V5_Civil CDs_comments.pdf Markup Summary

CARUBIA PROPERTIES - GRADING AND EROSION CONTROL SITE DEVELOPMENT CONSTRUCTION PLANS

LOT 2, BENT GRASS EAST COMMERCIAL FILING NO. 4

PPR256

DATE: JULY 11, 2025
SCALE: AS INDICATED
DRAWN BY: JWD
CHECKED BY: JWD
PROJECT NUMBER: 2024-019
SHEET: C5.13
UIA - RPA EXHIBIT

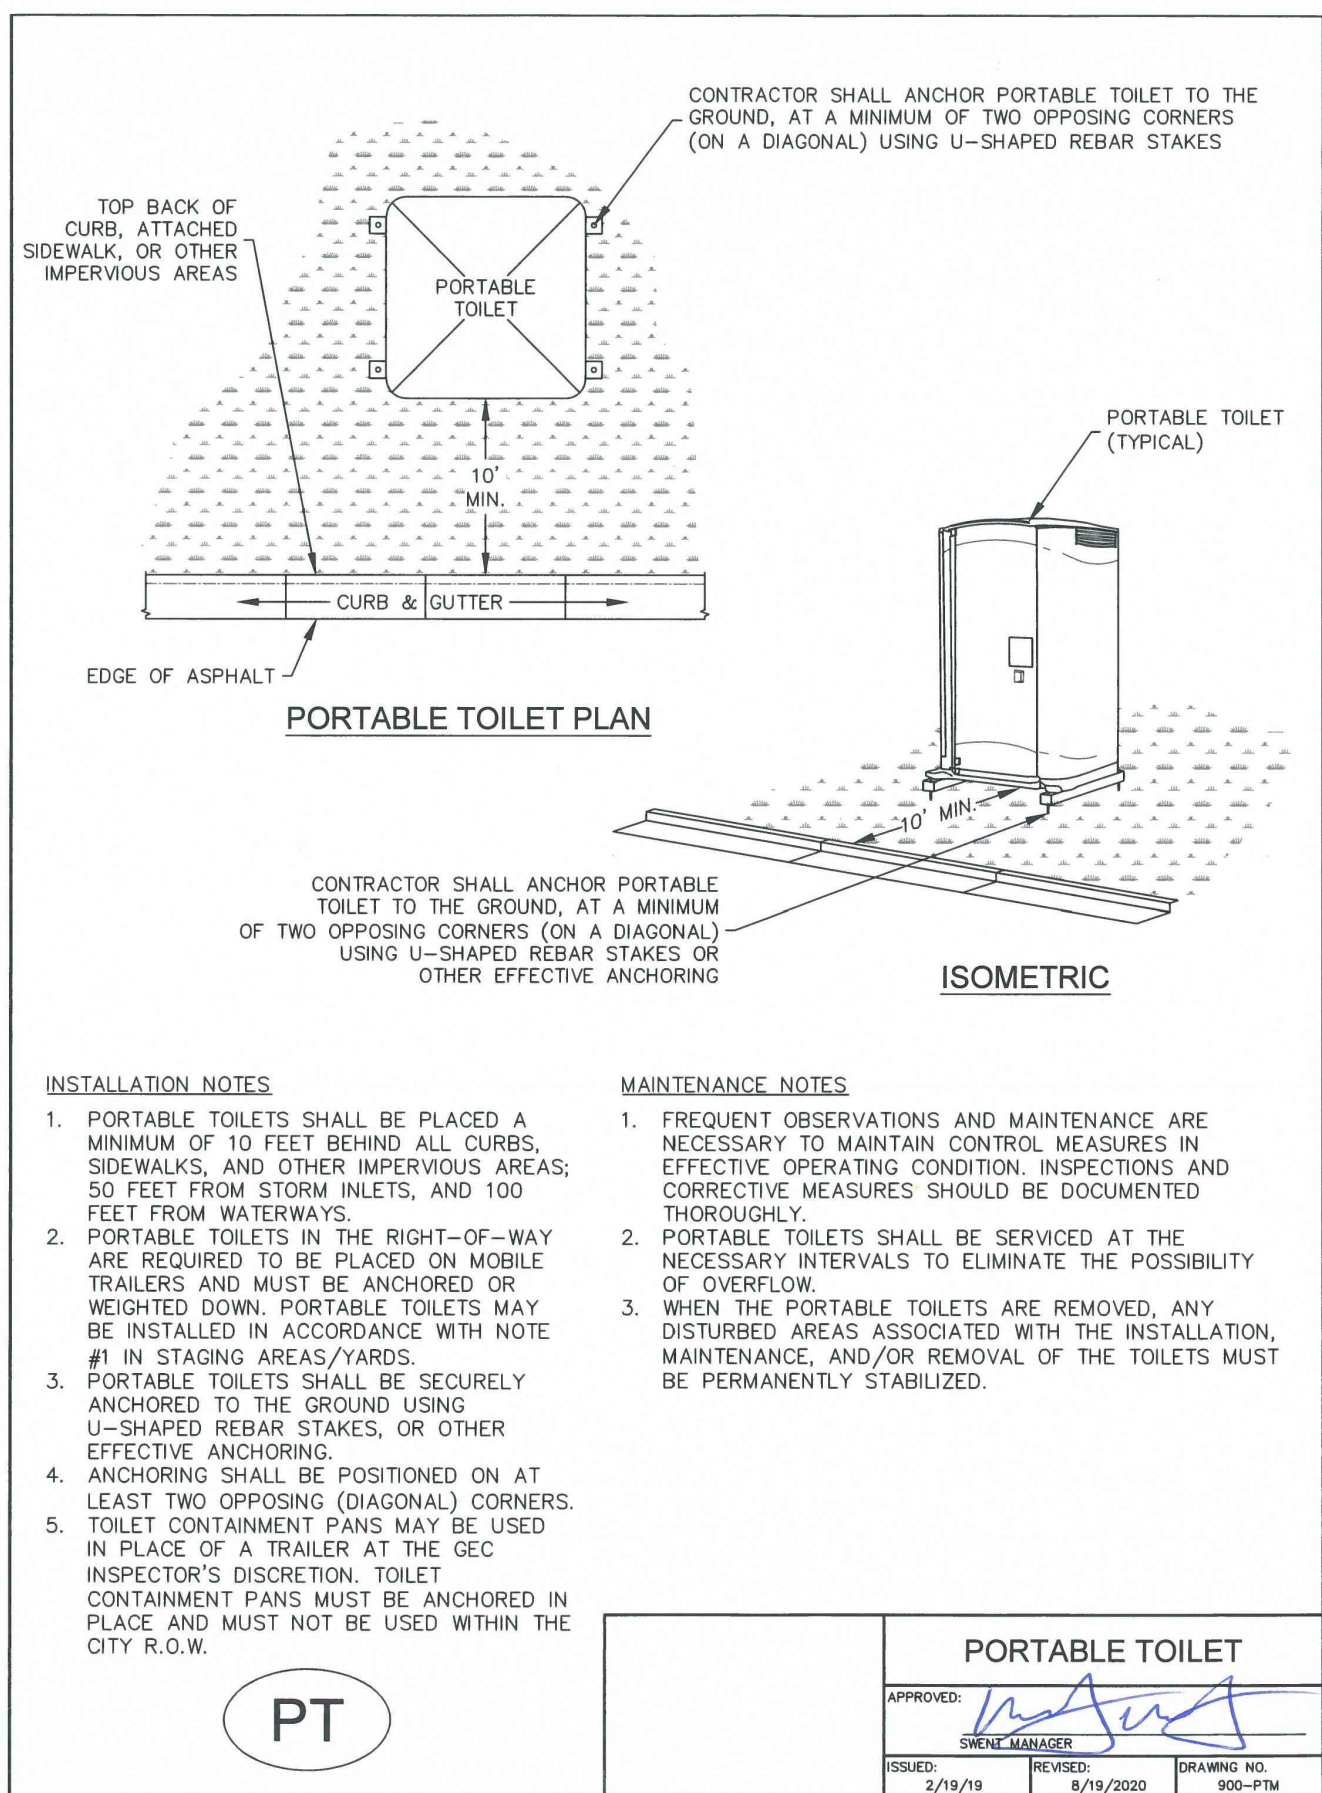
How this plan view, revise shape of both grass swales and inflows (and lack of level spreaders) per all my comments in the MHFD calcs in the Drainage Letter.

This SPA was appropriately shaded in pink with the last submittal. What happened? Please rectify.

Per the MHFD recommendation in the spreadsheet comment for this row, 2ft spacing on center is recommended.

You inputted 1' openings in the MHFD calcs. Revise to remove discrepancy. MHFD rec's 1.5' opening to protect from snow plow damage

MHFD recommends this be a vertical drop. In this case, there is high potential that the interface between the pavement/curb and the rock would get backed up with debris along the rock. With a vertical drop, this risk is much lower.

since inflows are via roof drains, they should be shown on this section.

revise inflows as needed per my comments in the MHFD calcs in the Drainage Letter.

Per MHFD guidance, Grass Swales are to be trapezoidal shaped.

SHEET
C3.11

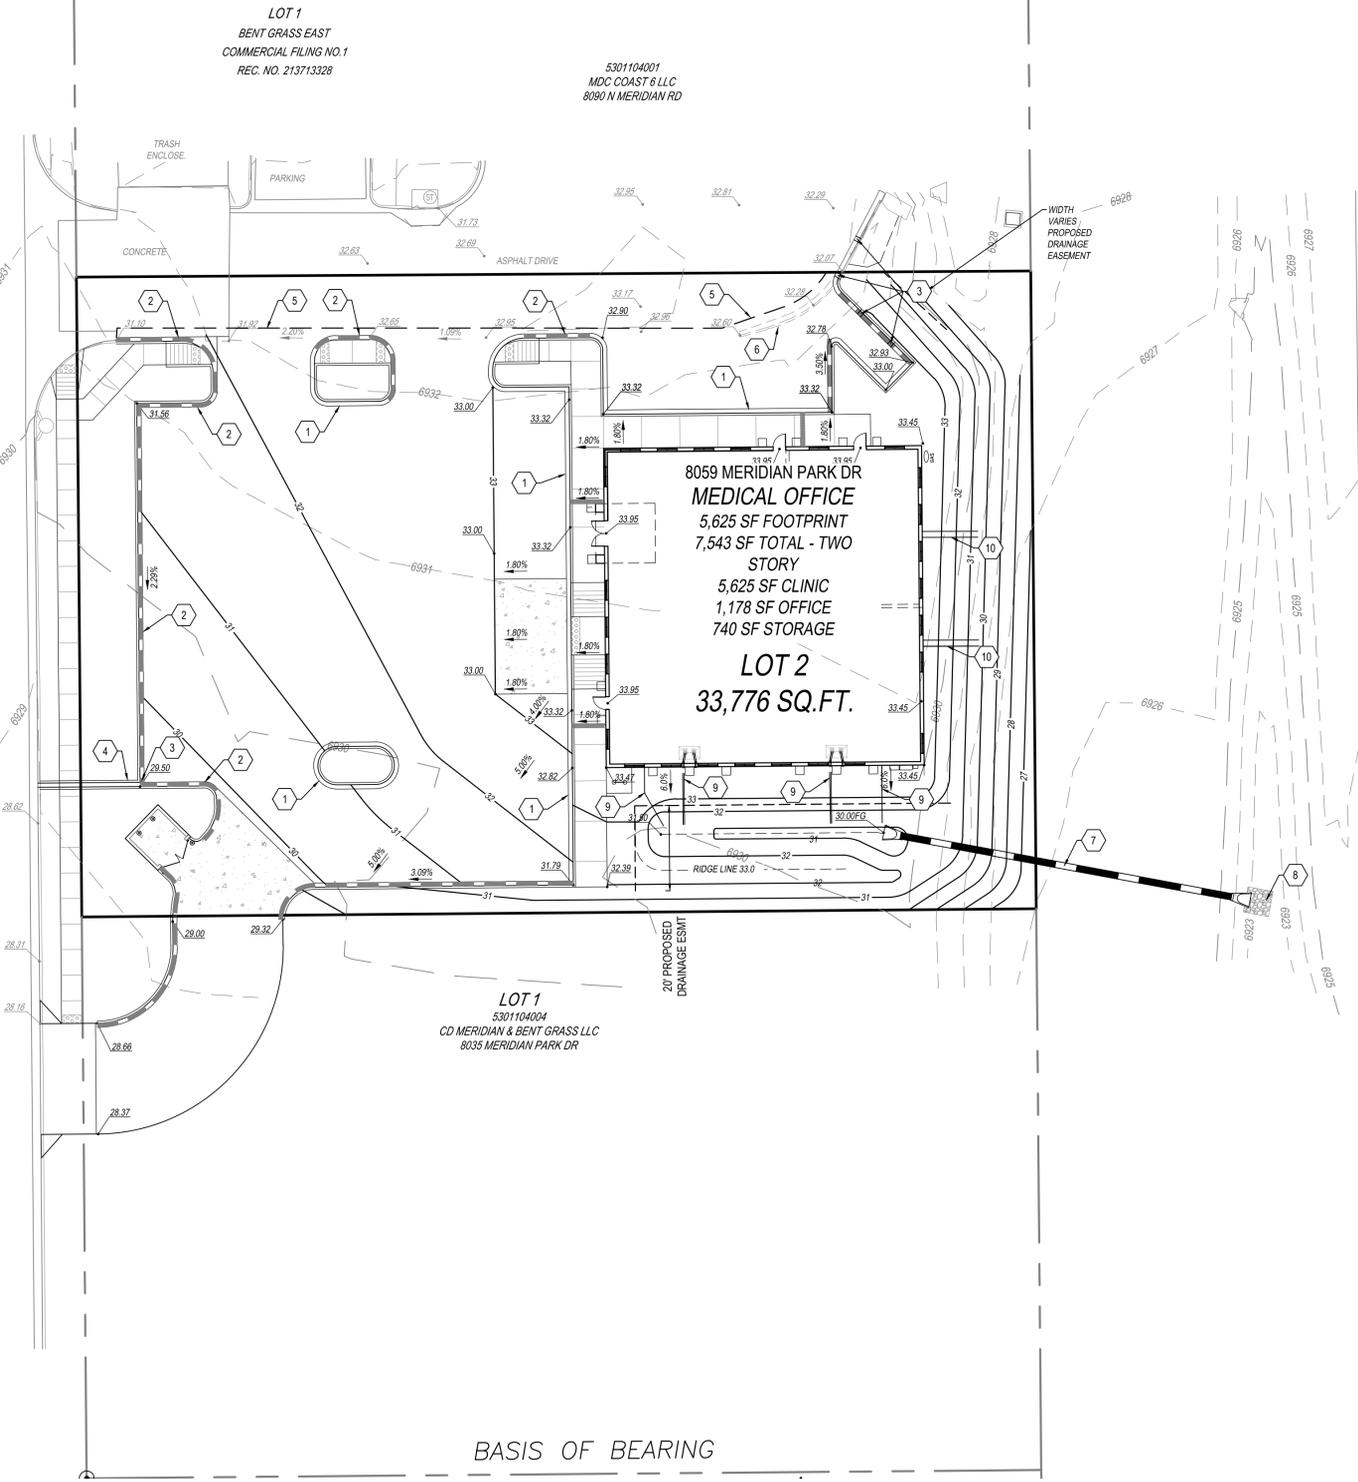
Revise notes as needed per my comments in the MHFD calcs in the Drainage Letter.

SHEET
C5.11

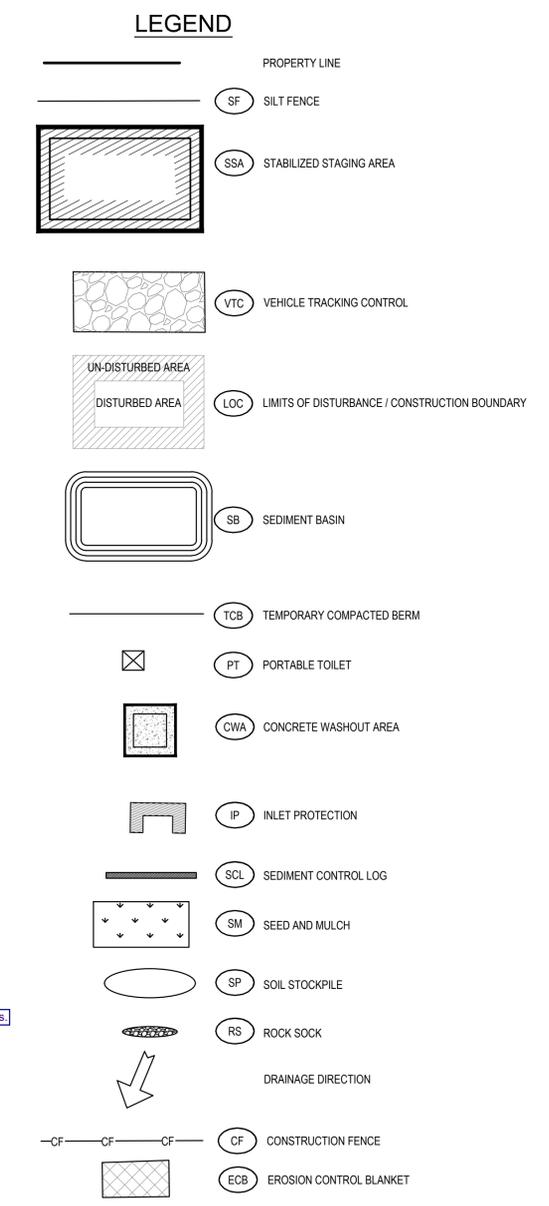
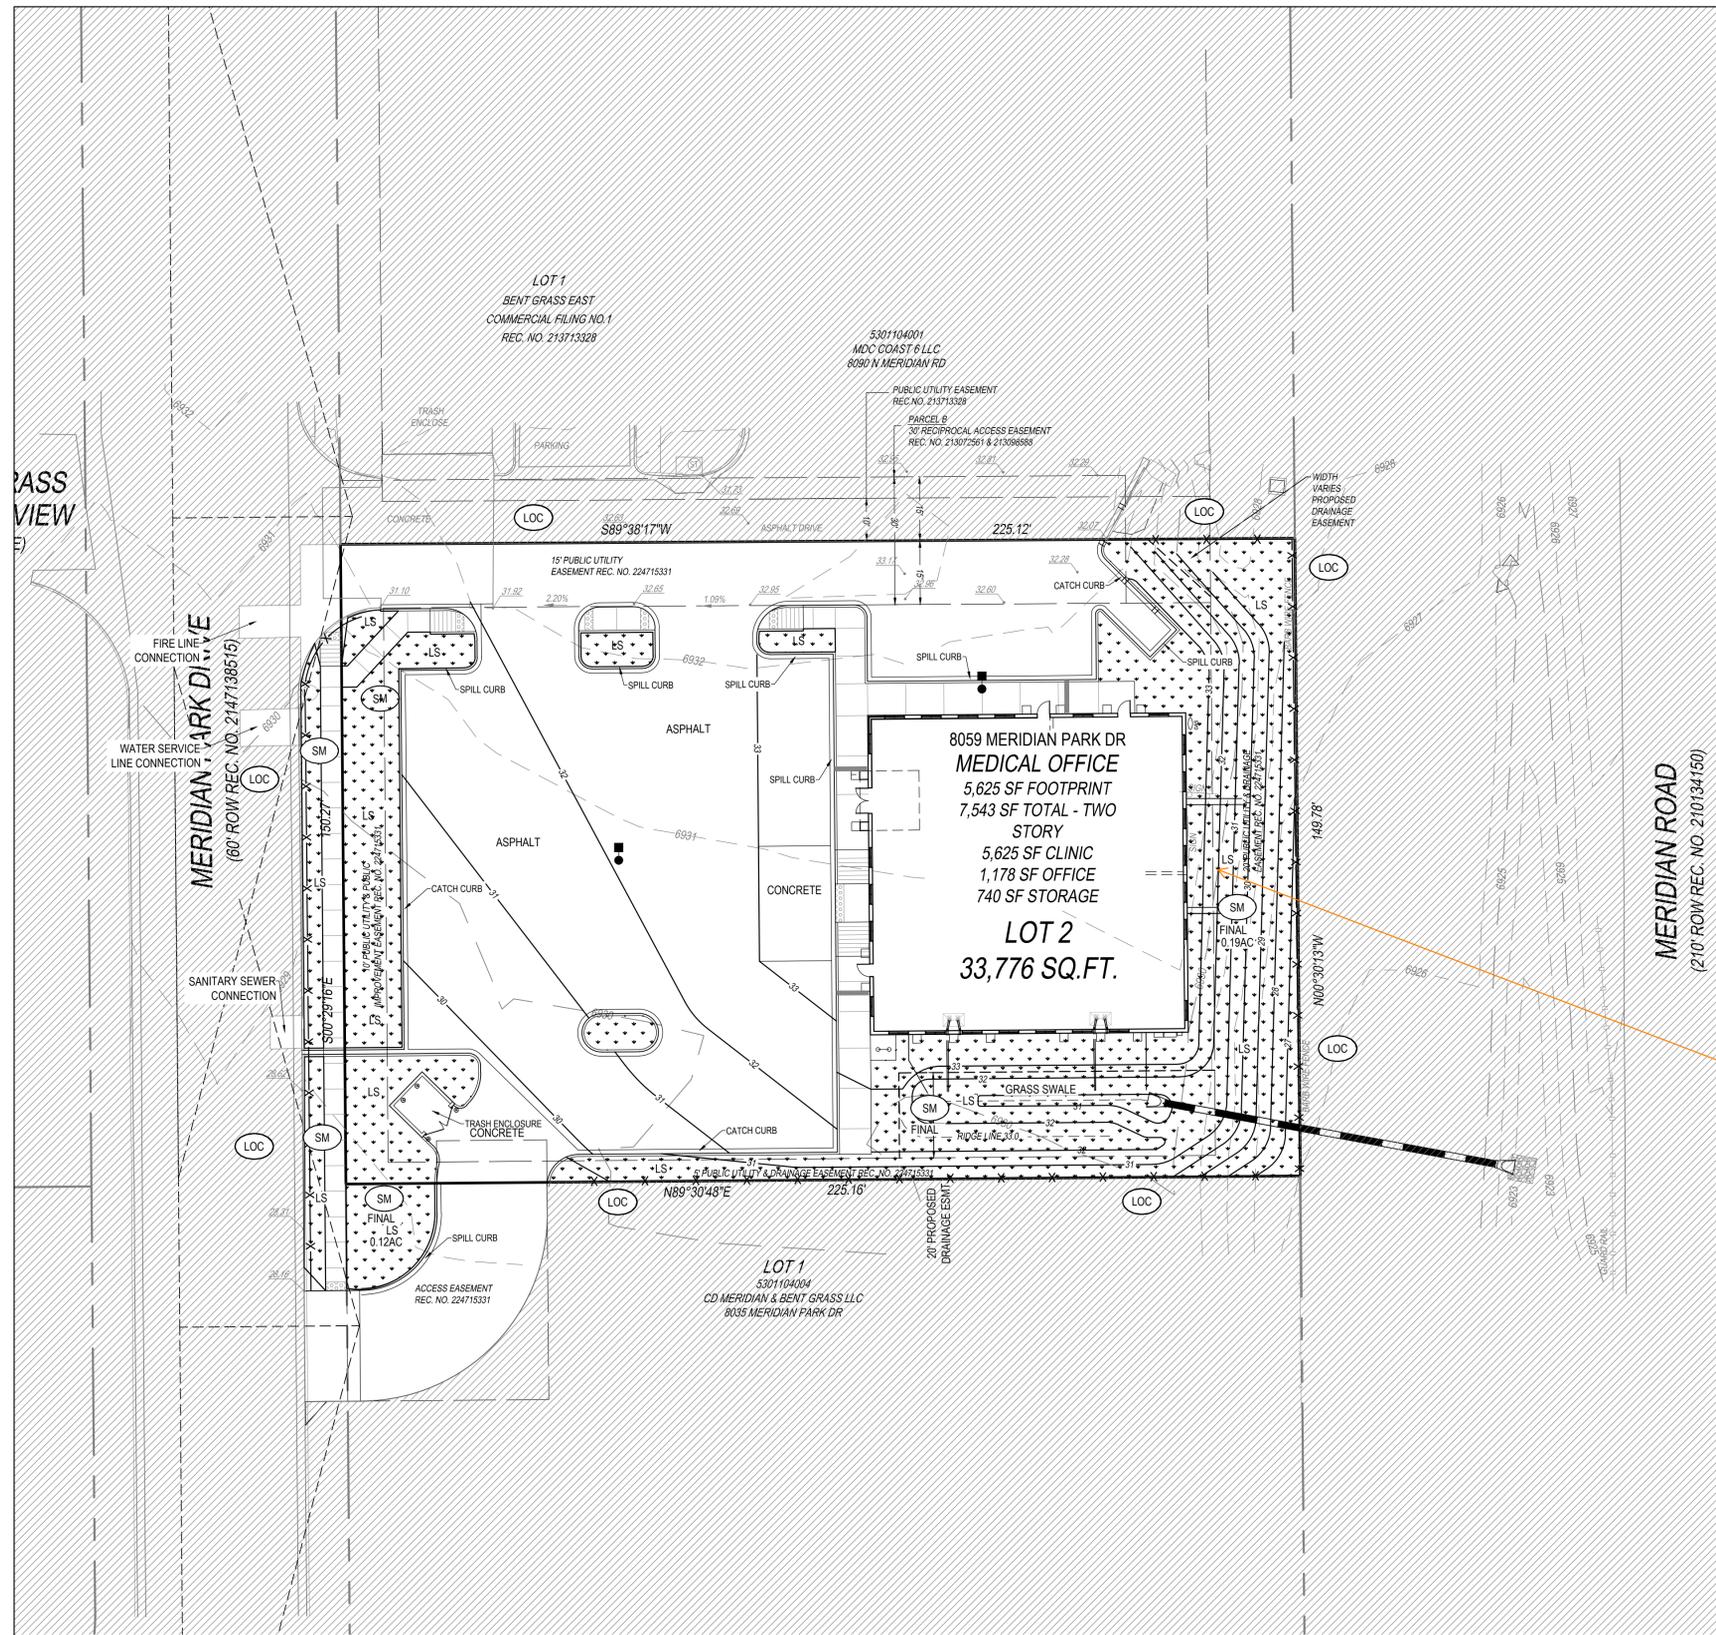
Per the blue shading on the next sheet, some of this area shown with SM hatching is actually rock. Please revise SM hatching and label/hatch as rock to account for this.

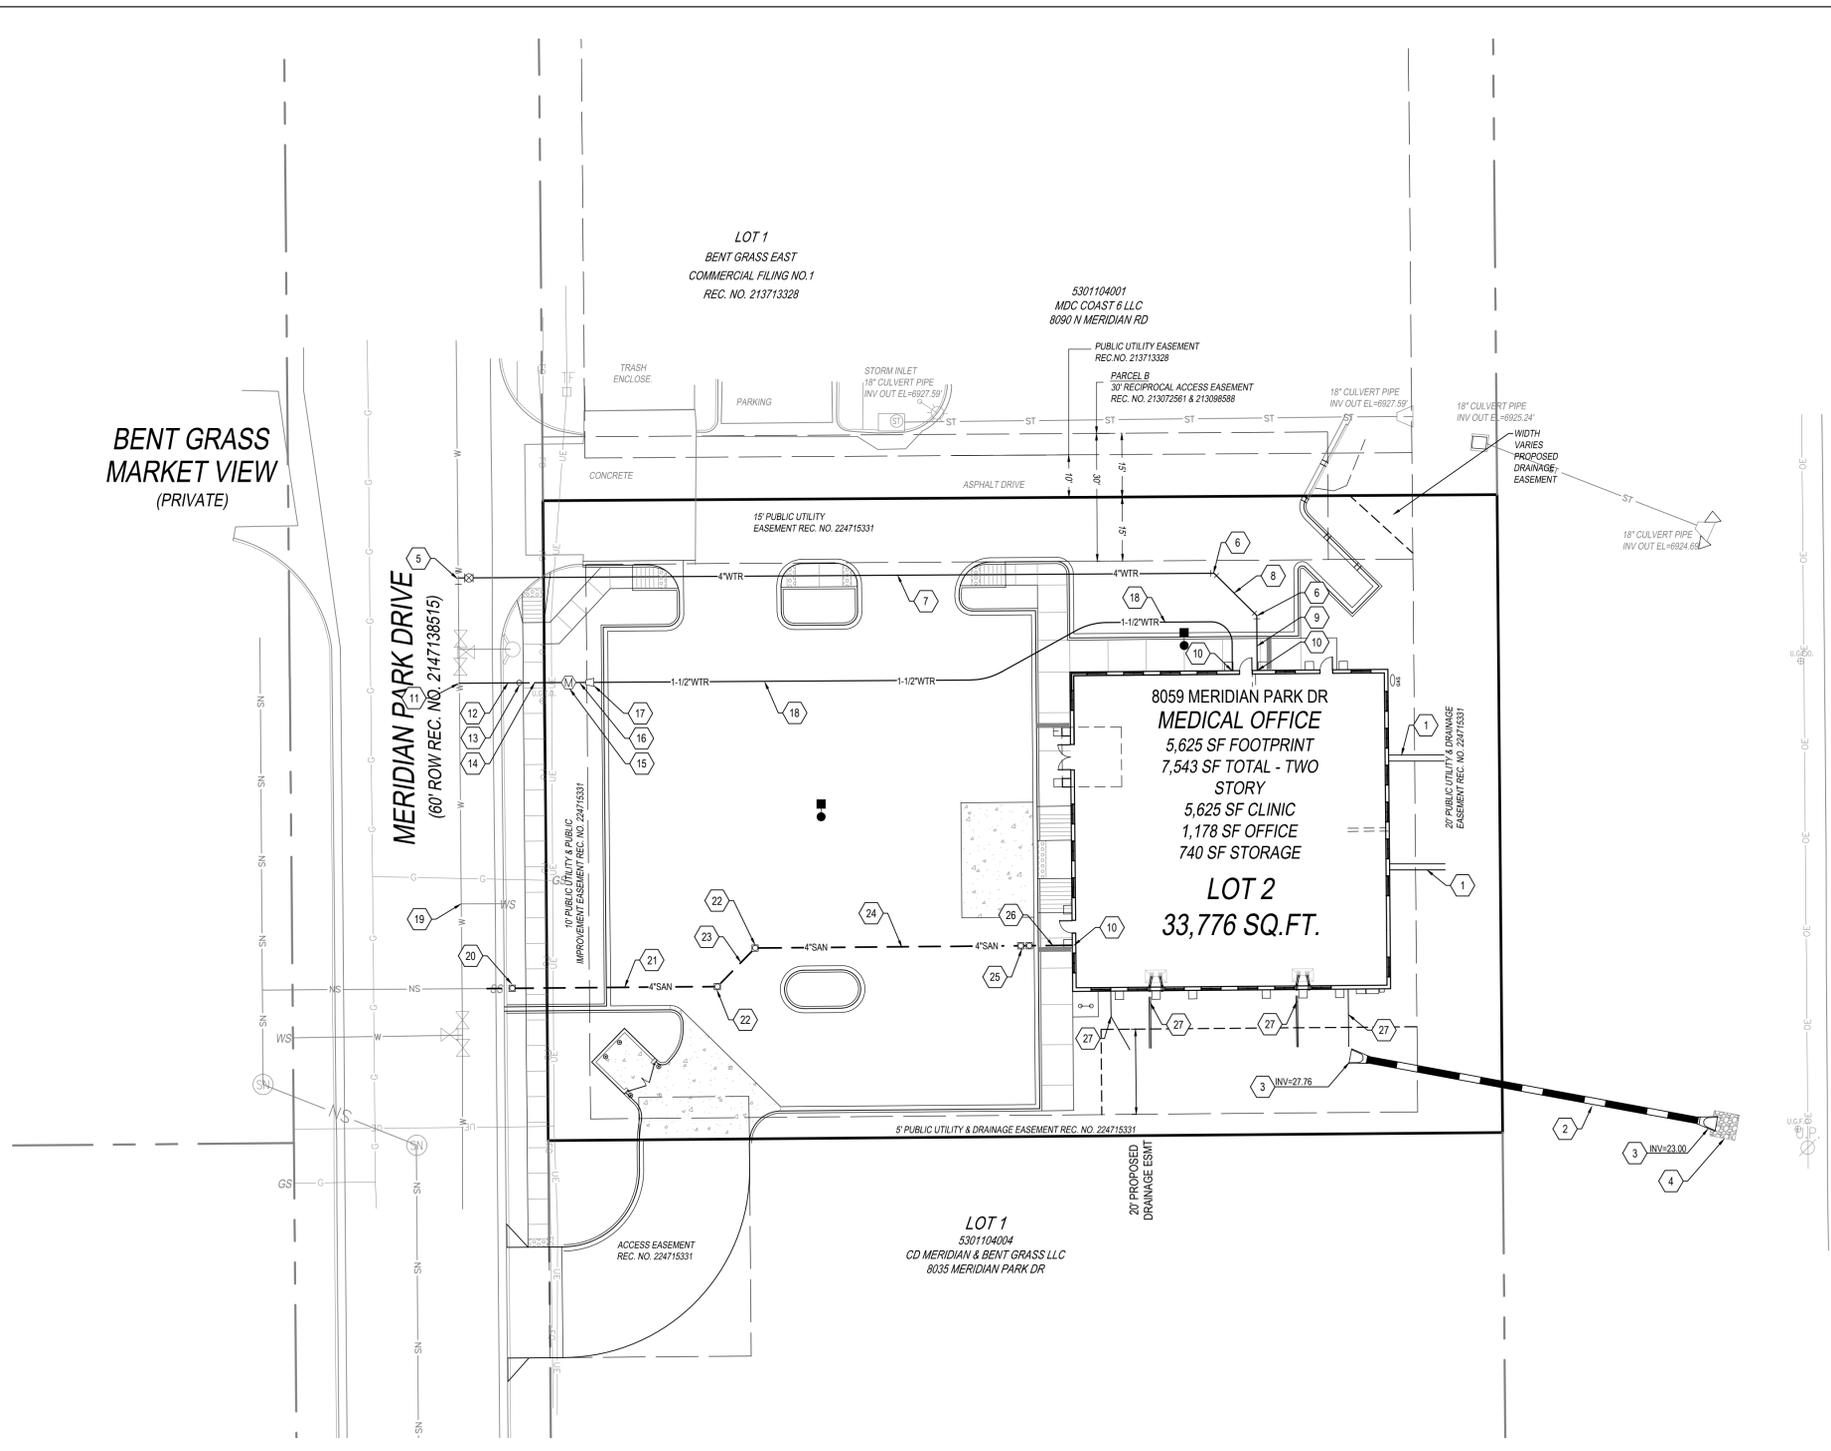
Still unresolved comment from previous two reviews: specify depth of riprap too
